**Our Ref: BR/337/19/HH**  
**Your Ref:**

**Town & Country Planning Act 1990 (as amended)**  
**Town & Country Planning (Development Management Procedure) (England) Order 2015**  
**Application for Householder Planning Permission**

**Development** Change of use from open space living room to 1 No. bedsit or studio with separate entrance  
**Location** 128 Collyer Avenue Bognor Regis

03 elevations
1:100

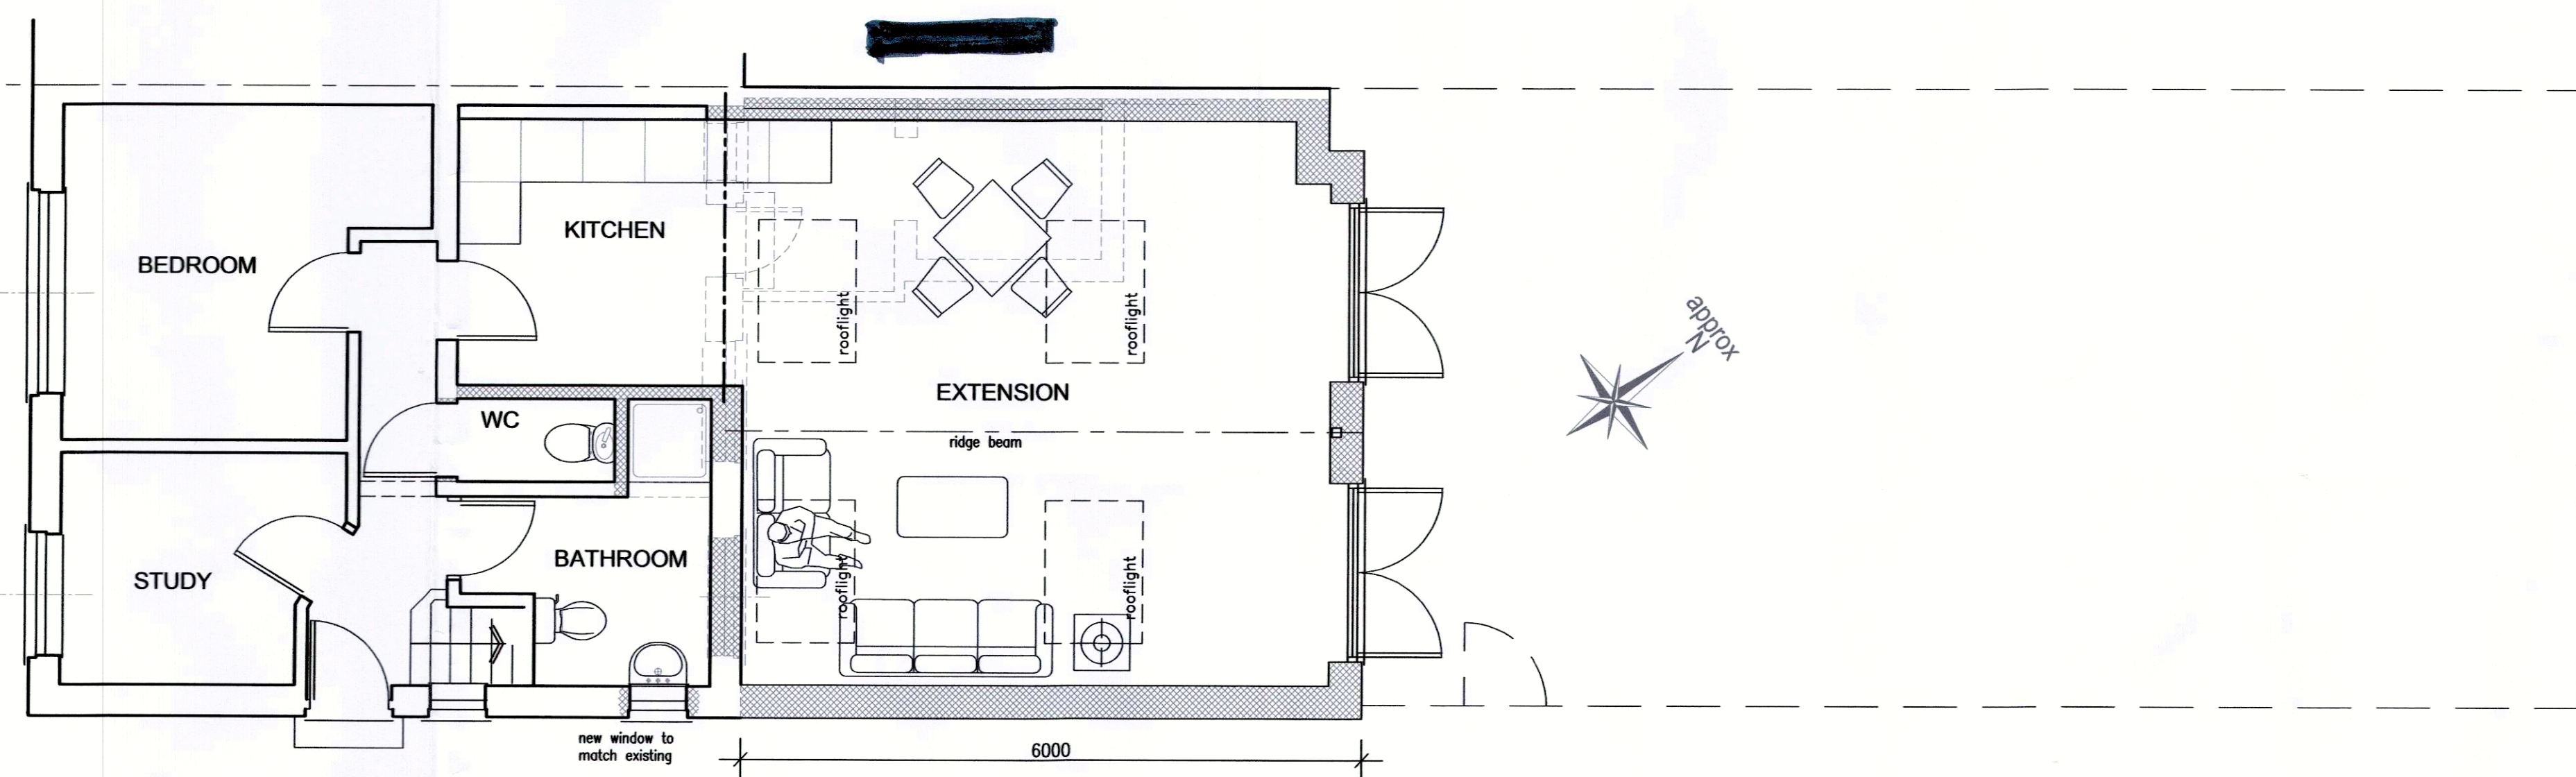
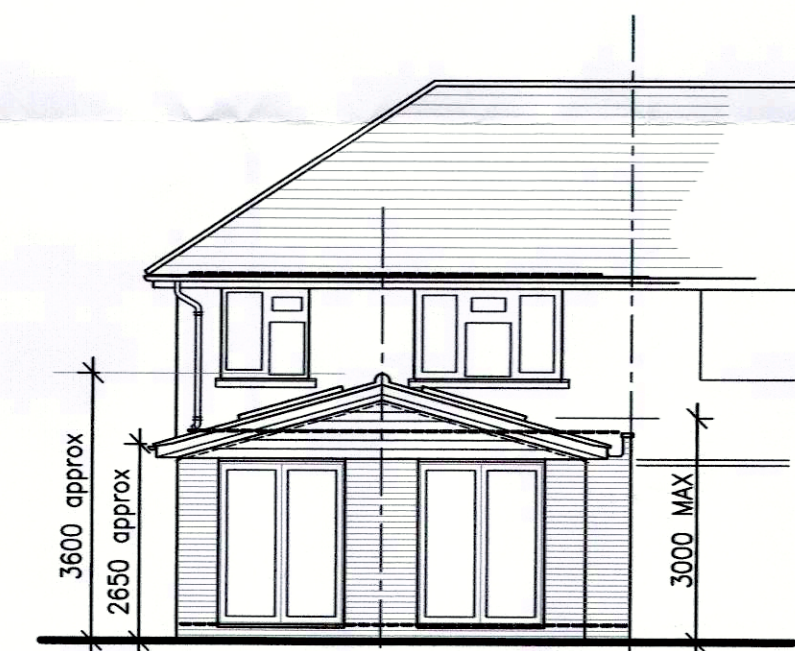
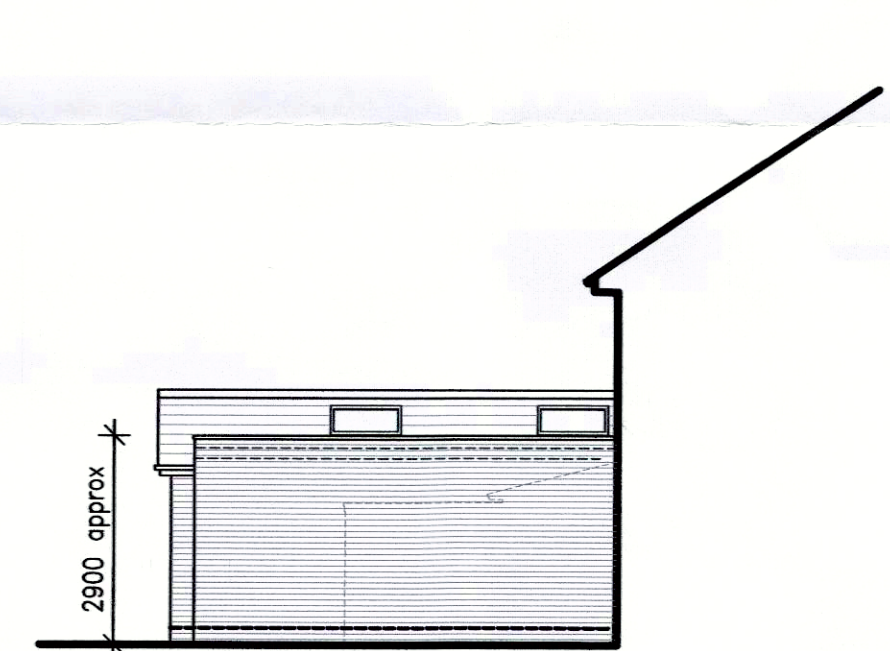
The plan labelled proposed has also been labelled existing at the bottom of the page. Please label b) side as Proposed, and all other elevations on this sheet as Proposed - no change.
